CITY OF ALBUQUERQUE
MUNICIPAL DEVELOPMENT DEPARTMENT
ENGINEERING DIVISION

HYDROLOGY SECTION FILE NO. 1-22 DATE 8/31/84

SUBJECT: 4-Plat E NE Corner Heinos & Zuna Lane
Lot 1 Blk 5 Juan Tabo Addn.

REMARKS: Approved Reanalysis Plan per DEM
required for sign-off

DRAINAGE PLAN

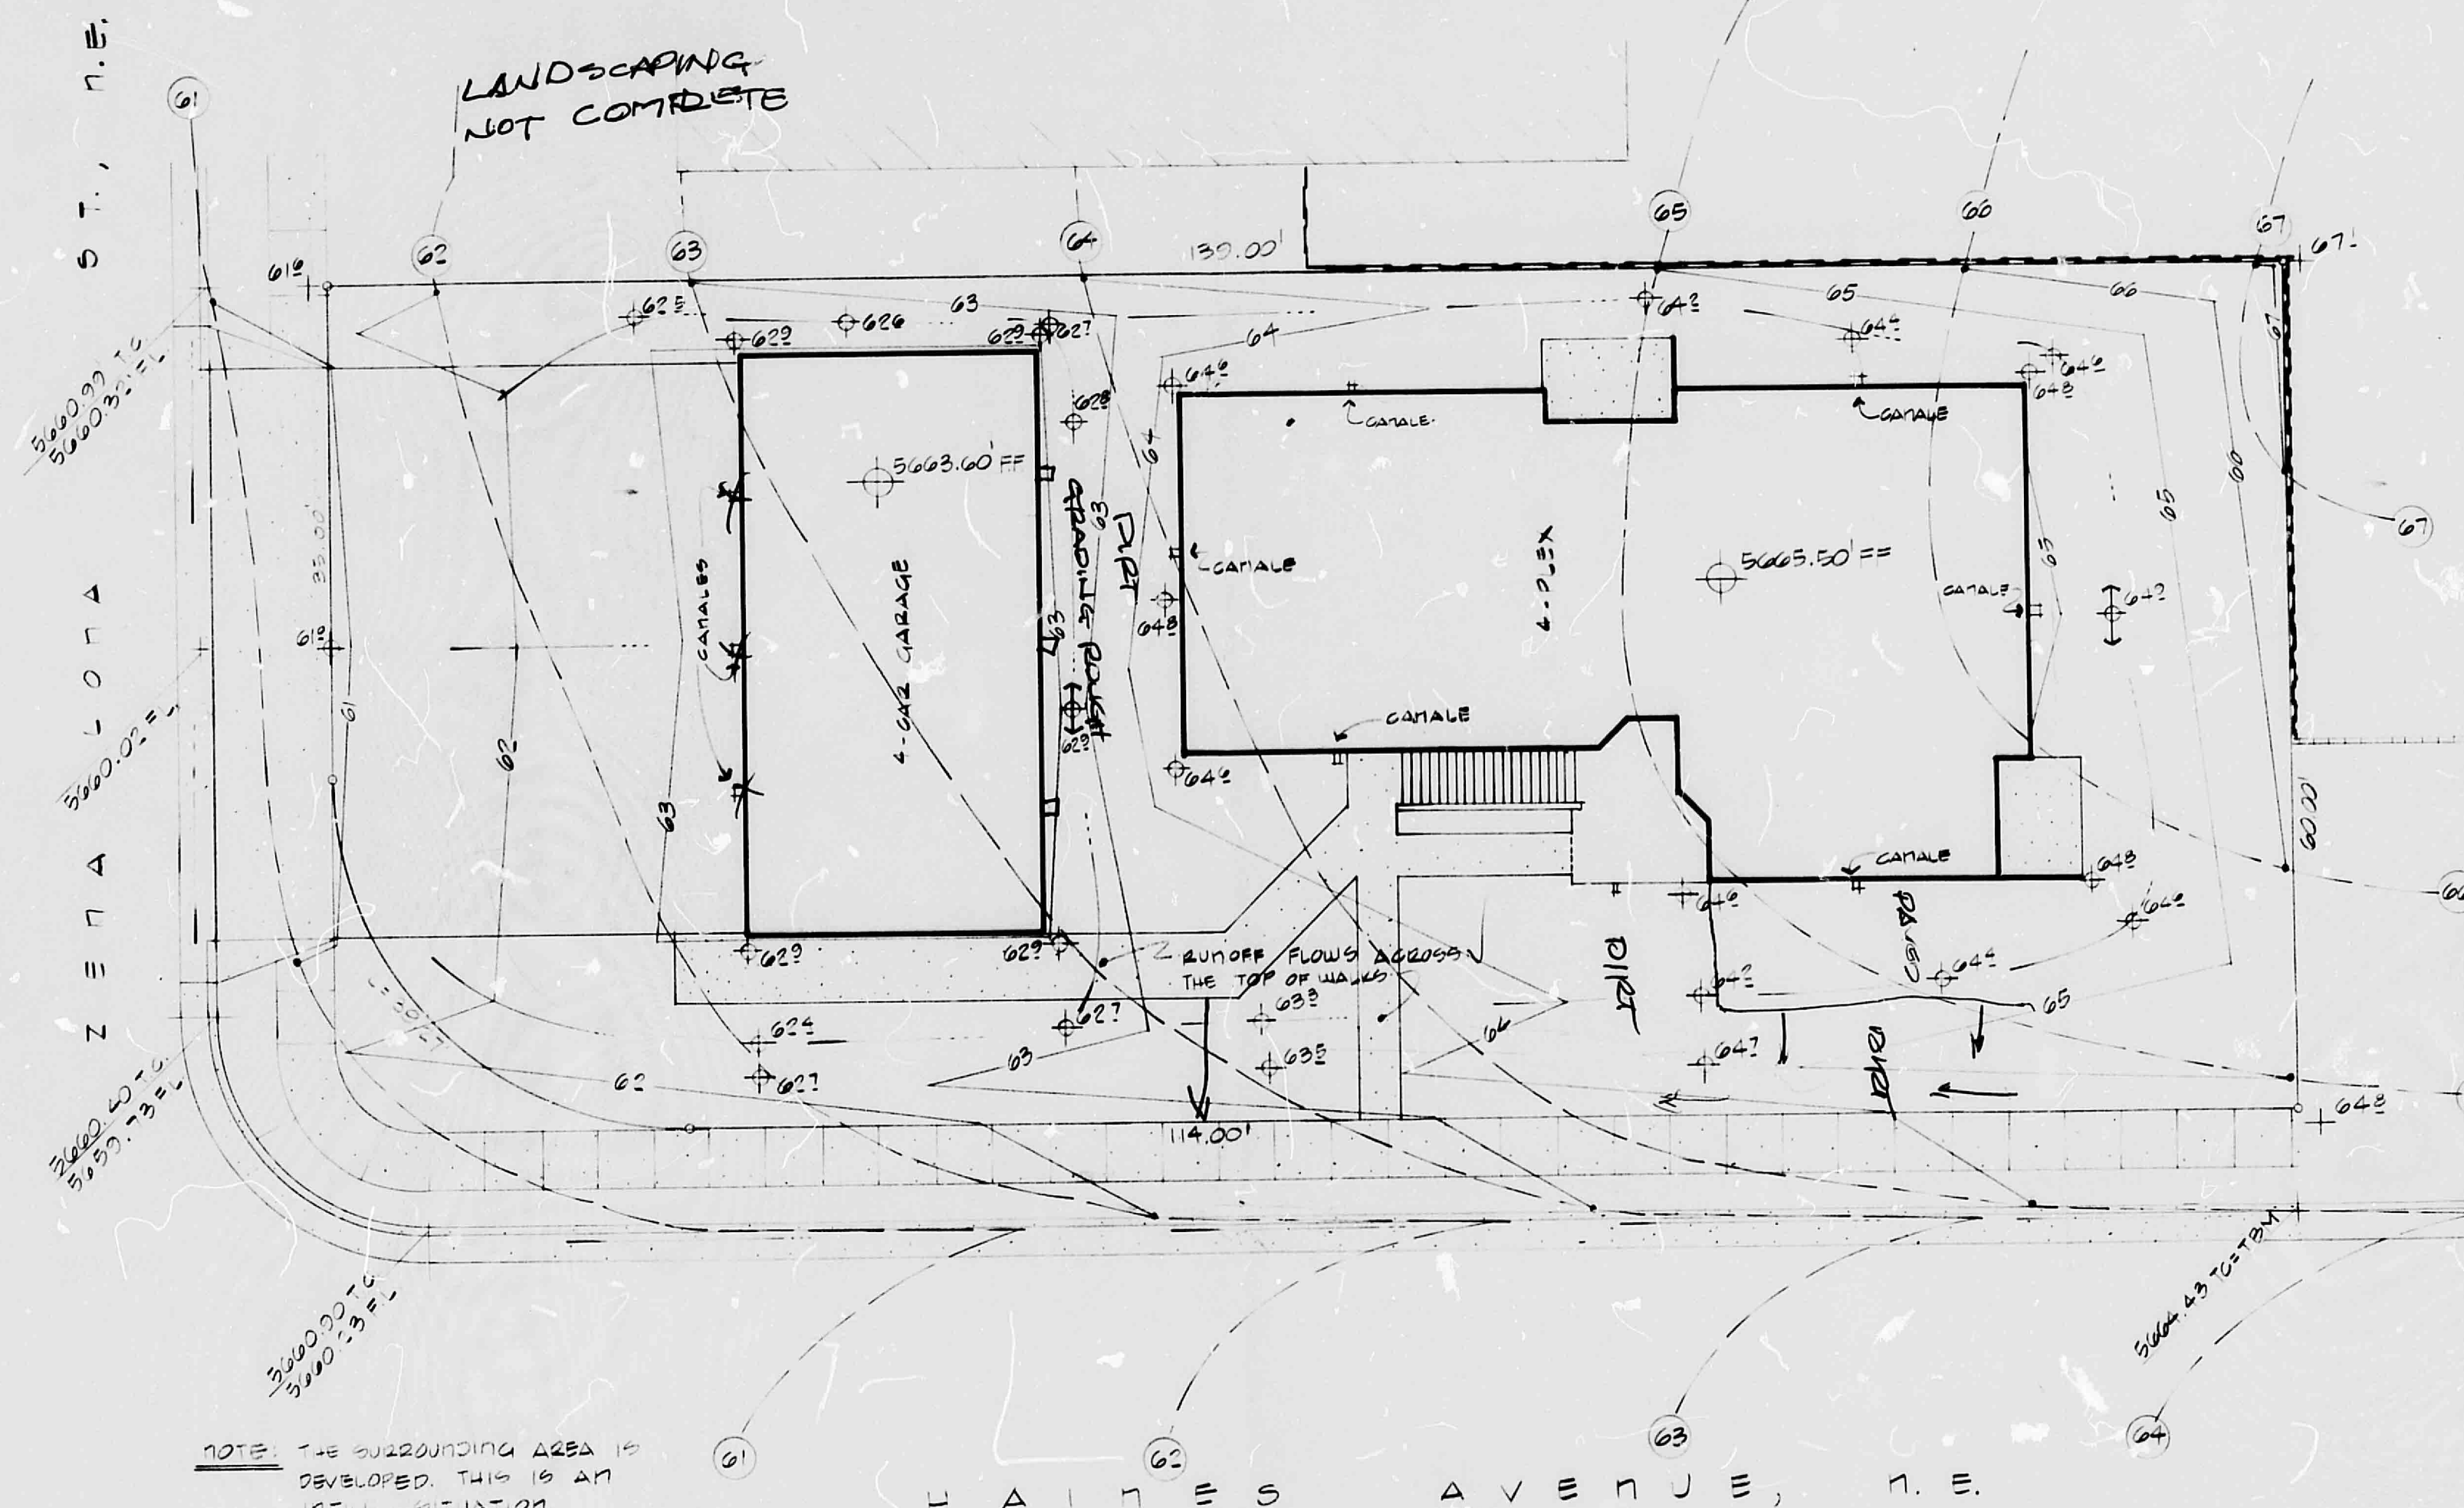
& Discharge to be determined by
analysis of downstream capacity

Please provide a copy of reanalysis/submit!
